Appendix A – Summary Response Table

Table 1 Summary of Issues

1. HEIGHT PLANE DIAGRAM - SOUTH-WESTERN CORNER

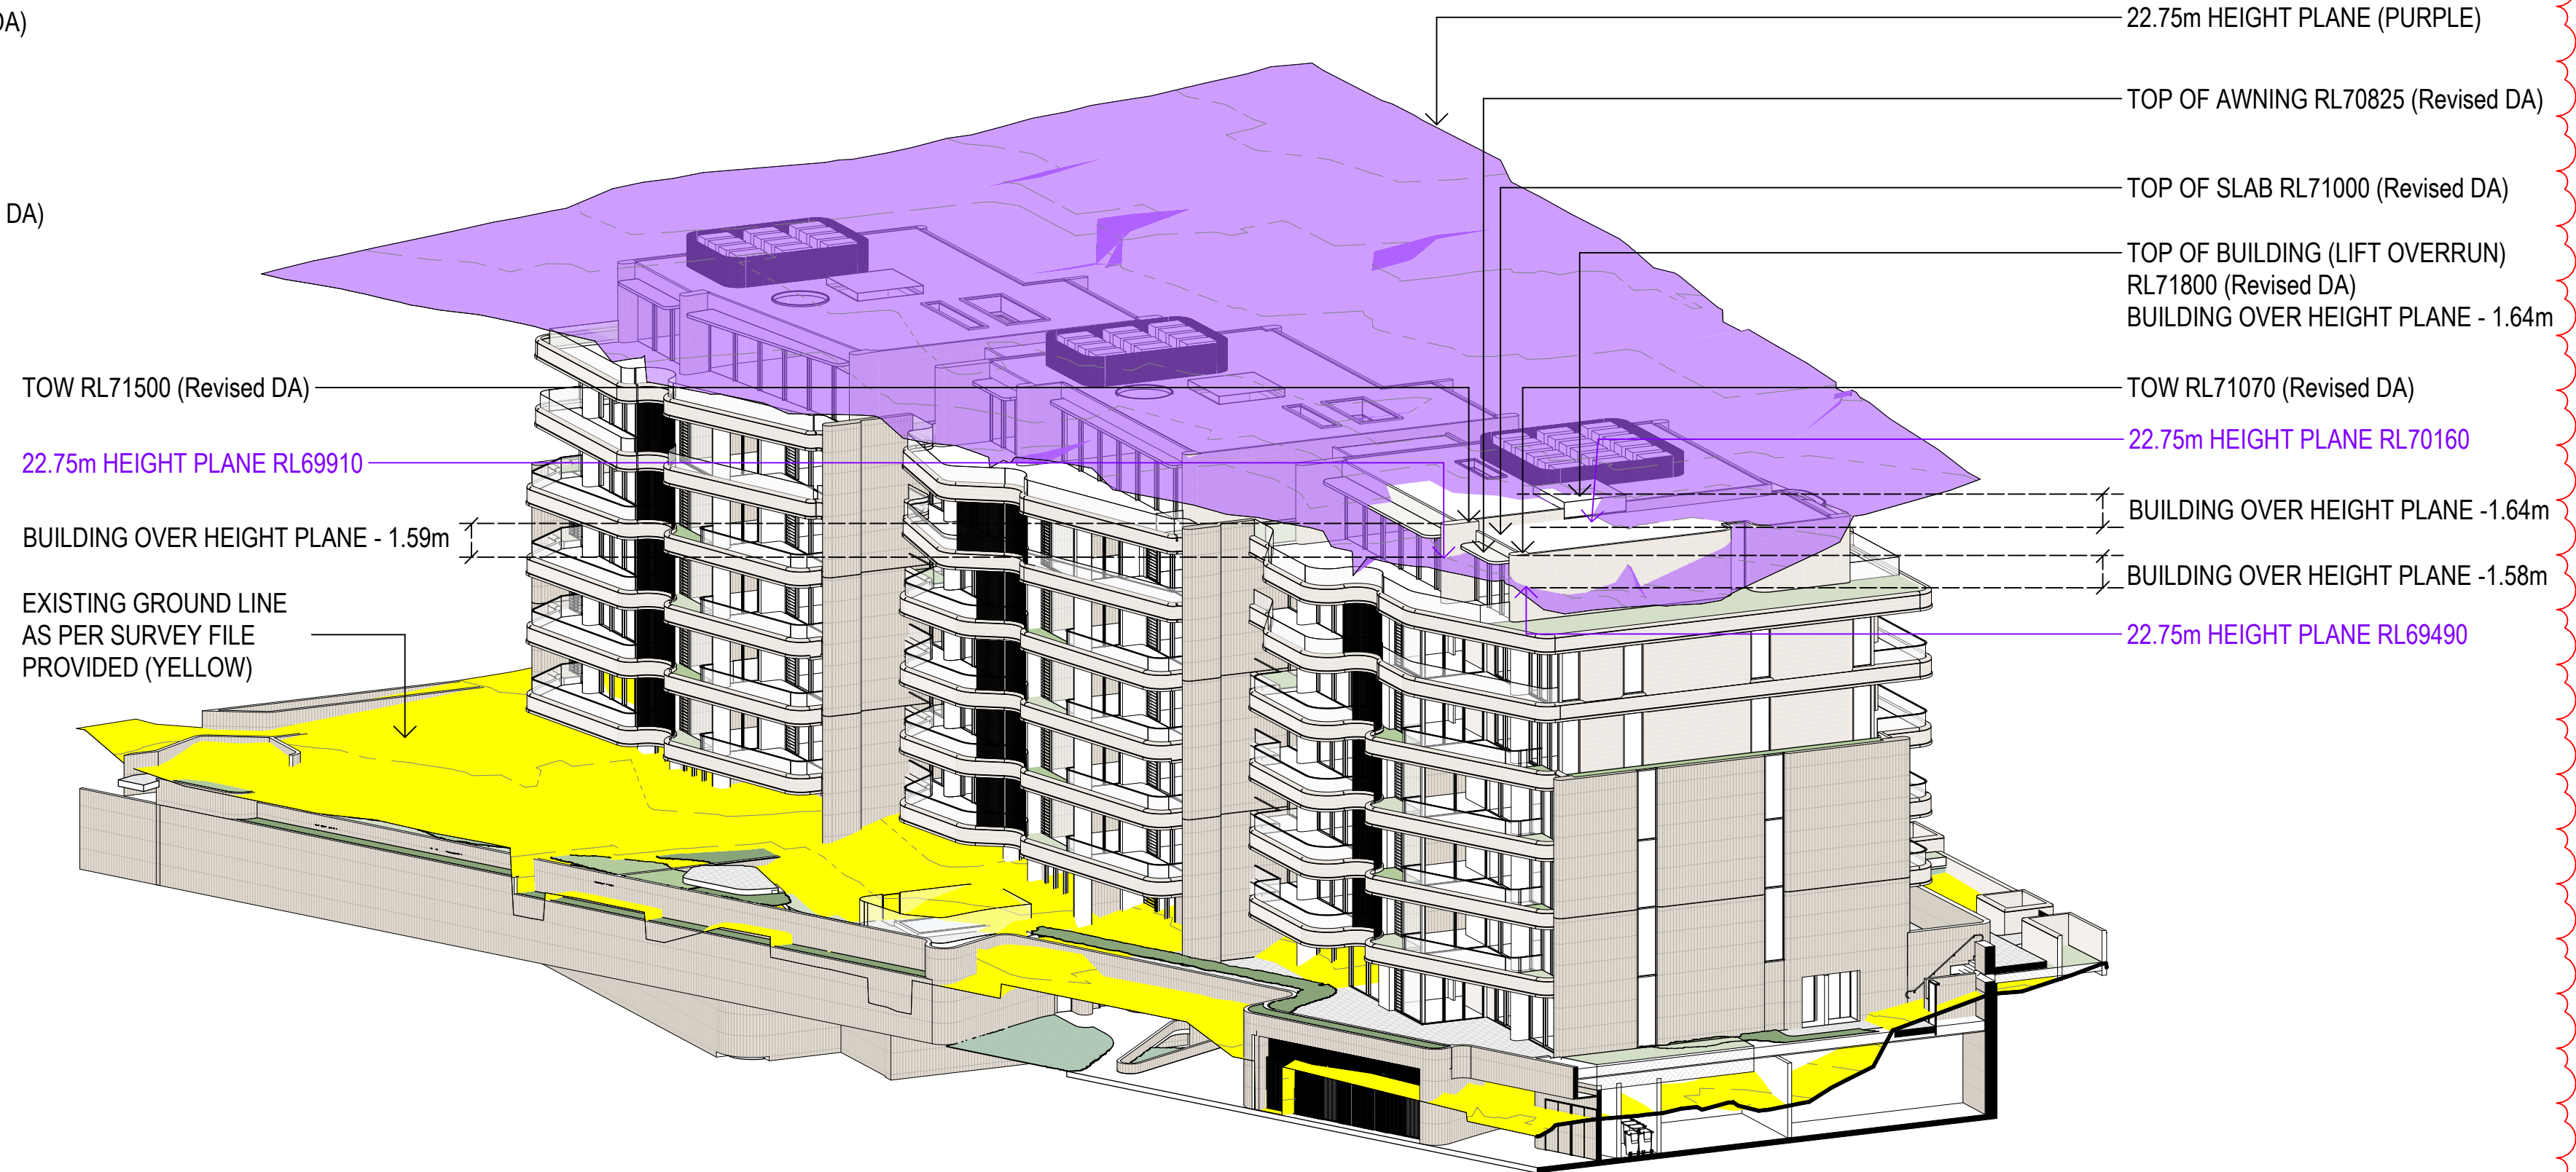
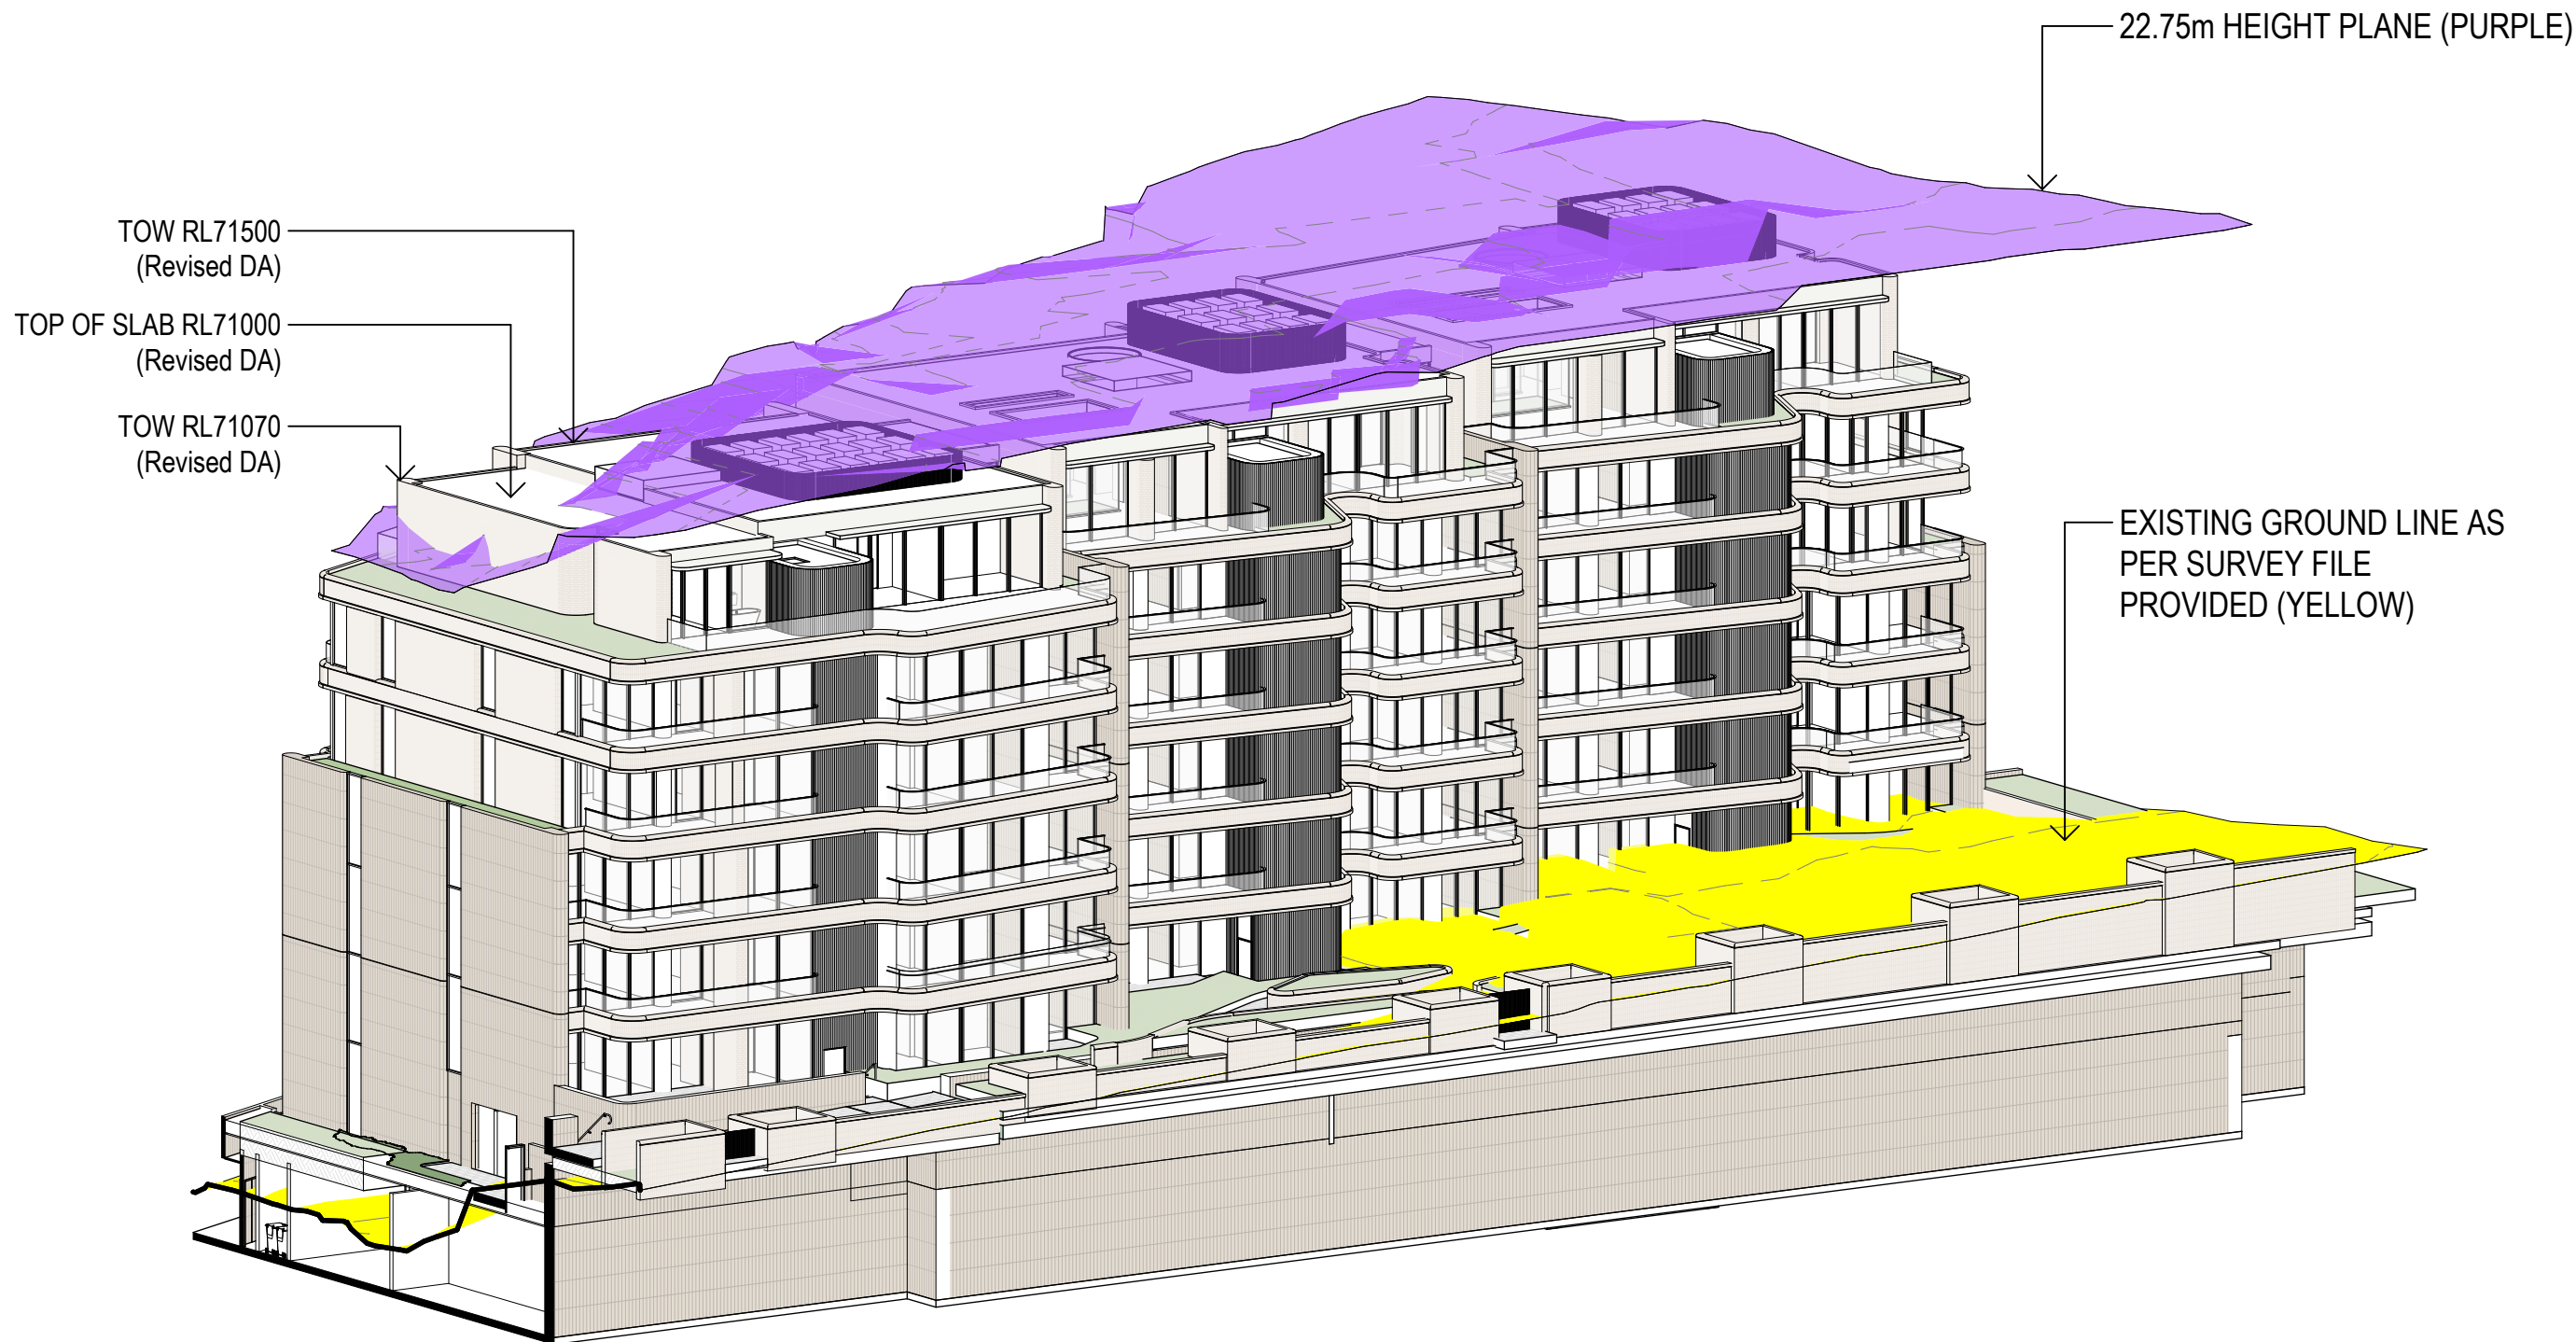
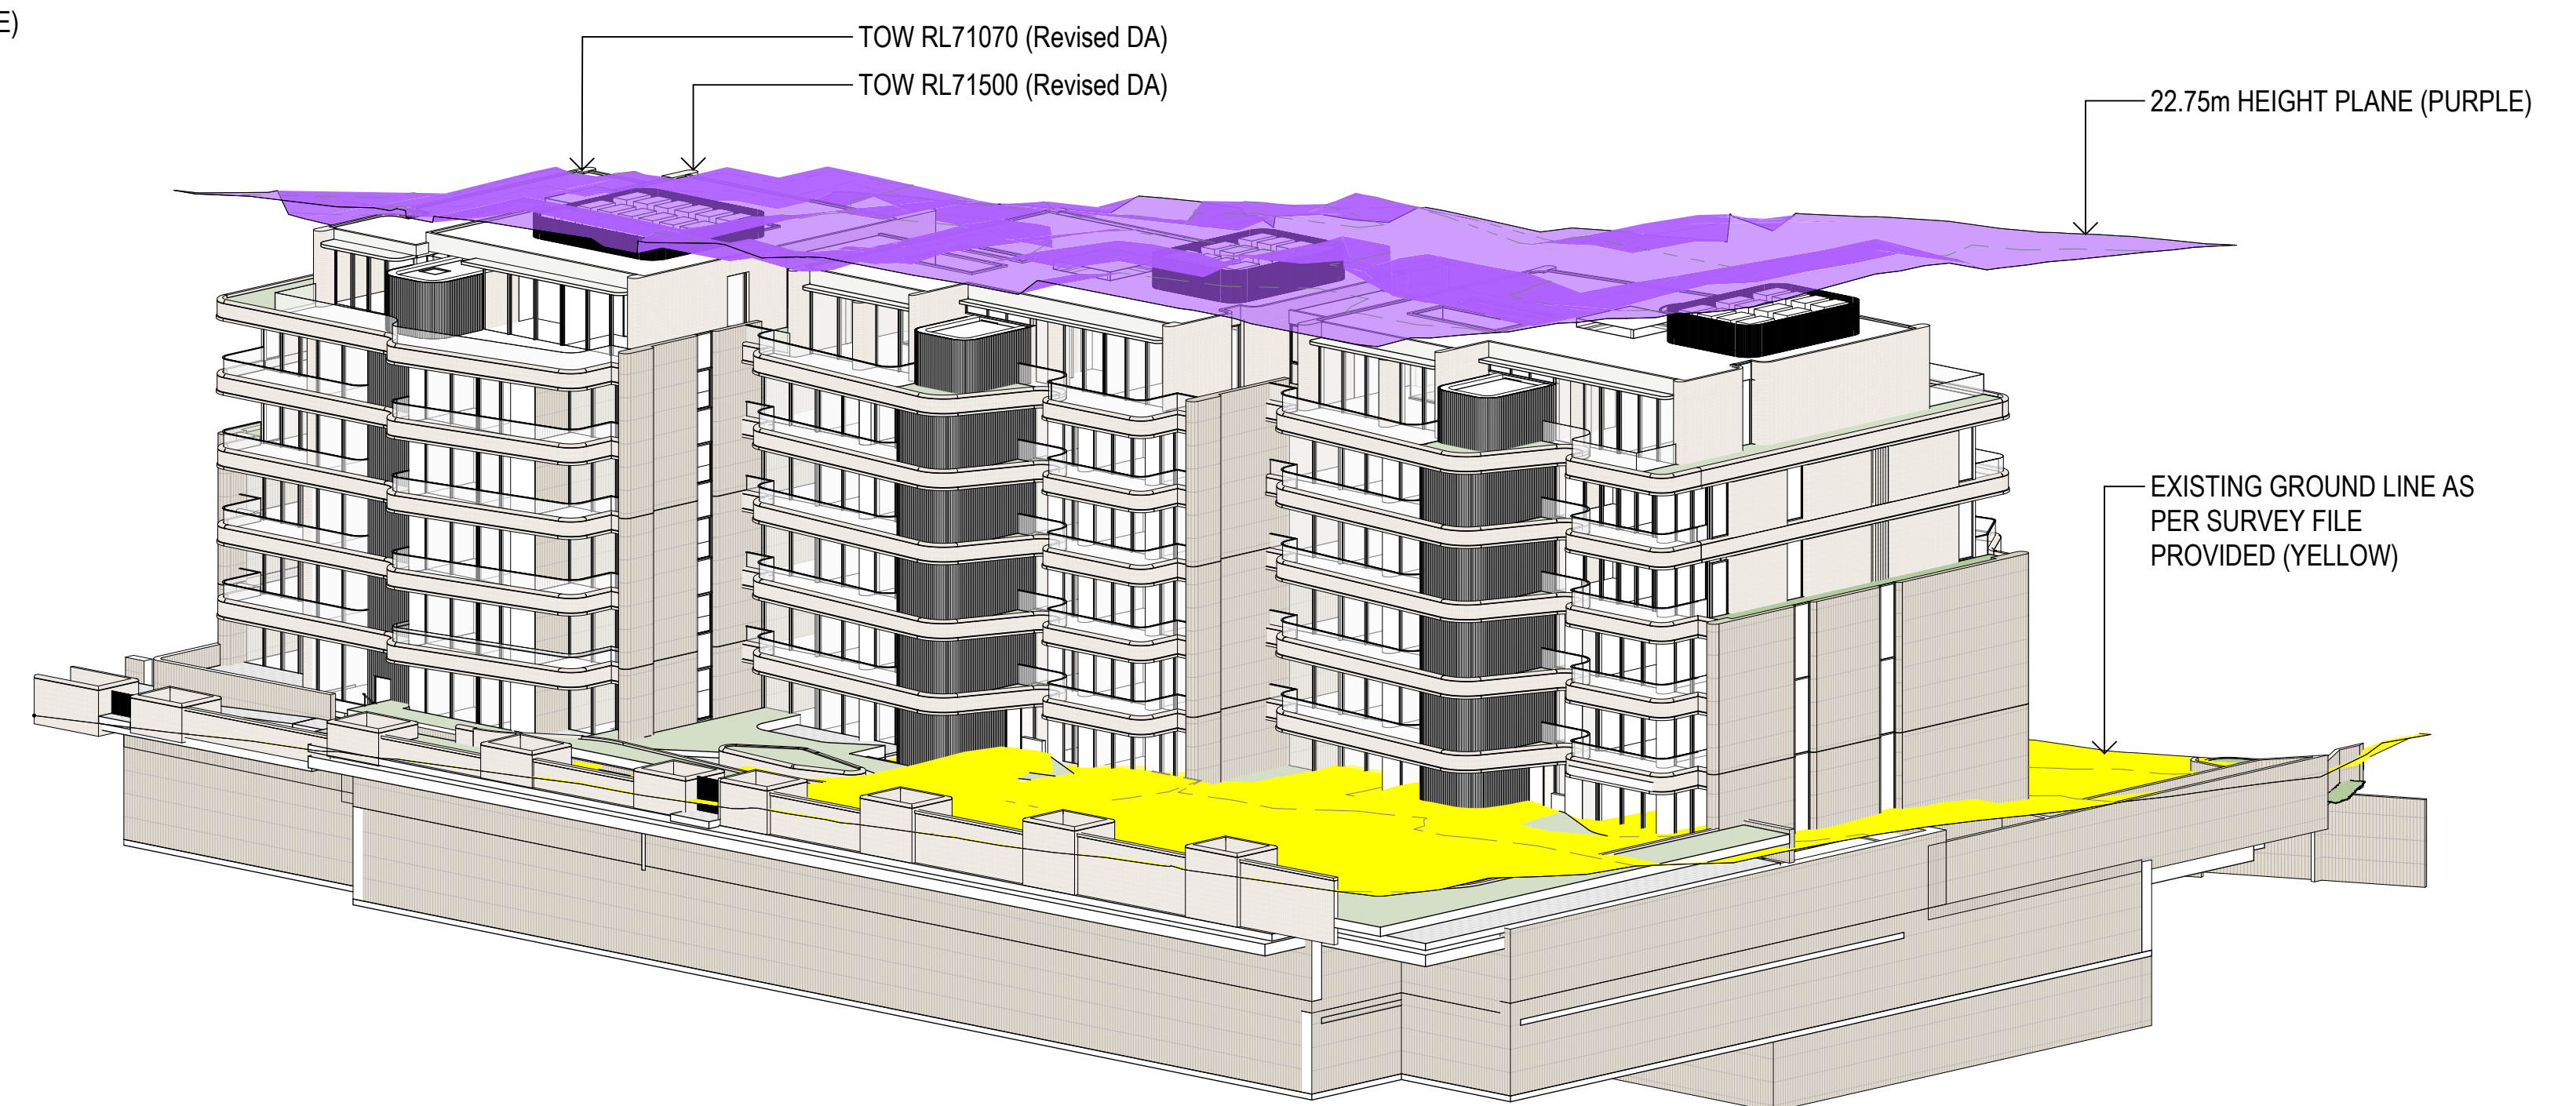
<u>Building Height:</u> 20. Provide amended architectural plans (including elevation and cross-section plans) to include annotation of the existing RL(s) directly below the highest point(s) of the buildings. 21. Provide an amended height plane diagram with annotation of the extent of the building height breach (in RLs and meters) based on the existing ground level RLs.	Amended Architectural Plans with annotation of the existing RLs below the highest point of the building and an amended height plane diagram with annotation extent of the building height exceedance is shown in Sheet No. DA5030. All cross section and longitudinal sections are depicted in Sheet No. DA5032, DA5033 and DA5034. As a result of the revised building design, the building height has been reduced, and the Clause 4.6 variation for Building Height has been updated.	RTS Appendix E

<u>4. Building Height, Wall Height & Clause 4.6 Variations</u> ▪ Council calculates wall height to be 25.061 (RL 71.83 Wall/Parapet and RL 46.229 Ground) instead of 20.7m wall height on Clause 4.6 ▪ Council calculates building height of 25.66m (Top of parapet – RL 71.830 and Ground – RL 46.170) while clause 4.6 states 25.597m ▪ Wall height development standard should be 7.2m instead of 7.5 nominated in the Clause 4.6 ▪ Council contends that greater wall height occurs in the south-east instead of south-west. ▪ Council believes there is no merit in allowing any variation to height requirements given in-fill affordable housing bonuses given to site in a highly sensitive area. ▪ Site is inappropriate for in-fill affordable housing bonus under the In-fill Affordable Housing Practice Note (December 2023) as the site is located within the Scenic Protection Area and fails to provide appropriate transitions to low scale residential properties to C4 Environmental Living and Holt Estate Heritage Conservation Area	The architectural plans have been amended which has resulted in a reduction in the building height exceedance and wall heights. The clause 4.6 has been amended to reflect the revised building heights. It is noted that the breach in building height is directly associated with the topography of the existing ground level dropping and therefore an isolated dip in the site. The majority of the building is situated comfortably below the height limit.
